Response to Planning Application

From: Arun District Council Leisure & Greenspace

Application ref: AL/89/24/OUT

Location: Land adjacent Woodgate Nurseries West of A29

Illustrative Masterplan

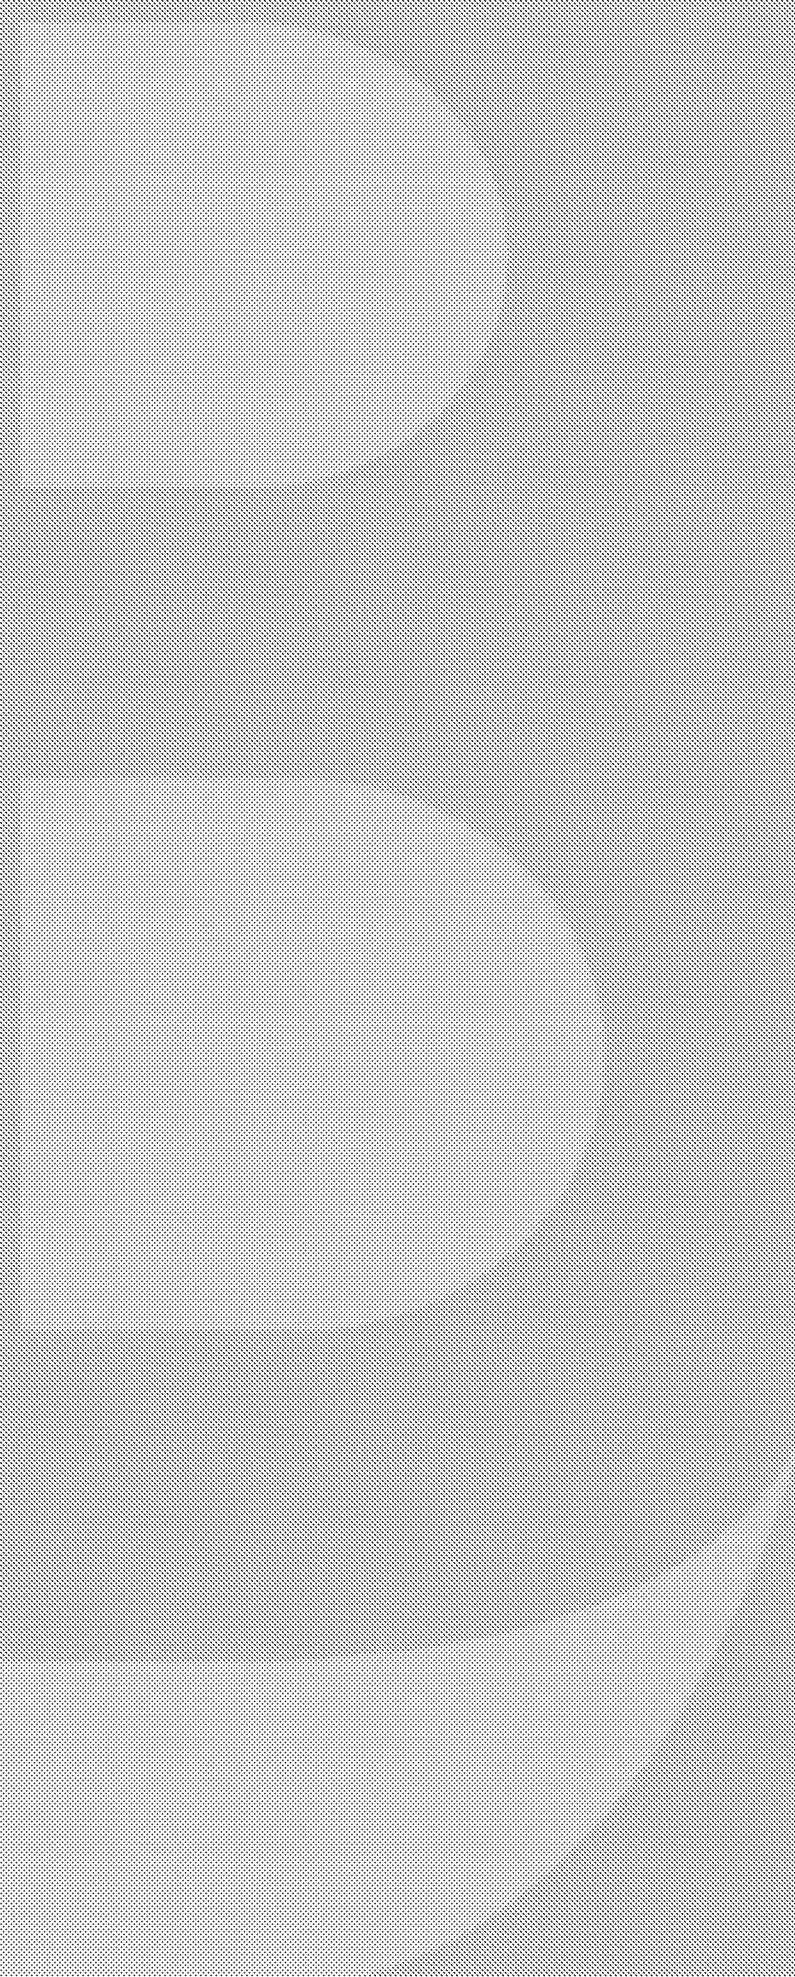
The information provided within the Pre Application Planning Statement and Sketch Masterplan have shown the dwellings clustered with much of the proposed public open space POS to the periphery areas of the proposed development and also to a large area of POS to the west of the proposals with footpath links to the development to the south.

The proposals as shown in the Illustrative Block Plan DLA.2222.L.04.S06 include Circa 3 hectares of Green Infrastructure providing 2.5ha of public open space to include 1 no. LAP, 1 no. LEAP, with additional incidental / doorstep play features, community growing facilities all set in a high quality landscape framework. A development of up to 130no units would trigger the requirement for LEAP and NEAP and several LAPs provision, therefore further play would need to be included. The NEAP provision in some form will need to be provided within this scheme and the DAS information *re 'within the context of the surrounding approved permitted residential schemes, the site will lie within the recommended walking distances to several proposed LEAPS and NEAP'* will not suffice. Each site needs to provide for its own development, however NEAP provision may be more appropriate to be in the form of play/fitness as more suitable for location and could better reflect the wider character of the setting.

Th play provision will require further detailed submission and approval. Play would need to be suitable for location in material choice and play experience offer, be inclusive and accessible in line with the now adopted SPD 13 Arun District Design Guide January 2021. Play needs to be well designed provide a varied and challenging play offer, accessed by all-weather pathways, contain seating, bins, signage, cycle racks and a minimum of 6no play experiences. The LAP location/provision does not appear to have been detailed within

the application.(the natural play LAPs required to contain features such as land form, natural play, boulders, logs, seating and bins)

Quality, well-designed Public Open Space will be fundamental to any proposal submission, this will need to accord with Arun District Councils OS SPD January 2020. There would be requirement for confirmation of the areas of public open space being proposed with this development, and clarification re quantum. The Landscape Masterplan shows where these are proposed, and also indicative SuDS features within these areas. Our SPD January 2020 would require 10,725m² as a minimum of well connected, usable, quality POS provision within this development, which appears to have been met with the inclusion of open space to the west.

SuDS Policy W DM3 of the Arun Local Plan requires development to integrate SuDS into the overall design of the development. The primary purpose of SuDS is to minimise the impact of urban development on the water environment, reduce flood risk and provide habitats for wildlife. SuDS should increase the levels of water capture and storage. It is essential that SuDS do not impact on the usable levels of public open space whilst providing benefit in the correct capacity within the development and should not be included in the 'usable open space calculations' SuDS feature are presently shown within the POS areas.
